**KIRKLEES METROPOLITAN COUNCIL
INVESTMENT & REGENERATION SERVICE**

Reference No: 2020/62/90386/E

Site Address: 1, Dartmouth Terrace, Woodsome Road, Farnley Tyas, Huddersfield, HD4 6UE

Description: Erection of two storey side extension, single storey rear extension, rear dormer extension and demolition of rear porch (within a Conservation Area)

PROPOSED PLANS AND ELEVATIONS

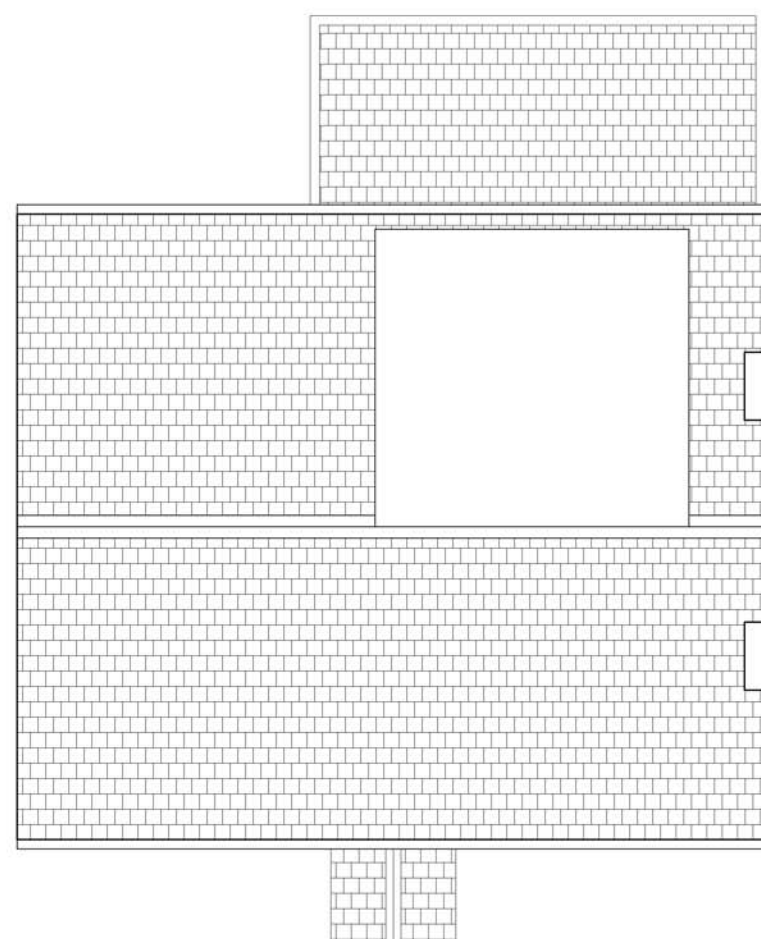
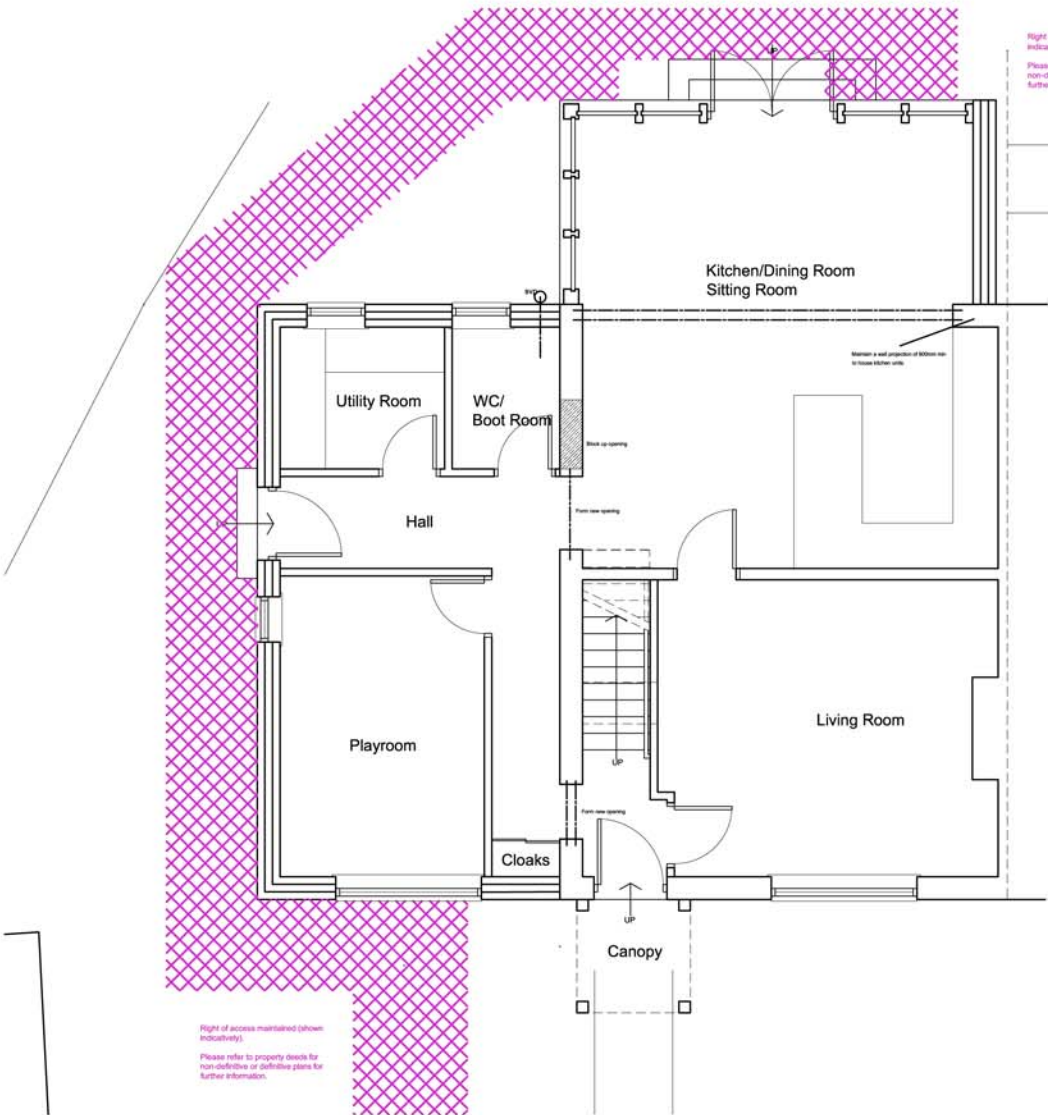
Officers suggested a minor change to the facing materials as the proposed off-white/ cream coloured render was considered to have an adverse impact on visual amenity. The agent was also advised to amend the site plan to make room for parking two vehicles. The amended drawings were received 24-Apr-2020 and 05-May-2020 and no further amendments were sought thereafter.

KC Conservation & Design Team – Subject to the coloured render being replaced by pebble dash render, we do not find the development proposal harmful to the significance and character of Farnley Tyas Conservation Area.

3. The external walls of the two storey side extension hereby approved shall be faced with brickwork and pebble dash render and the roofing material shall be natural blue slate tiles to match those used in the construction of the existing building at the application site.
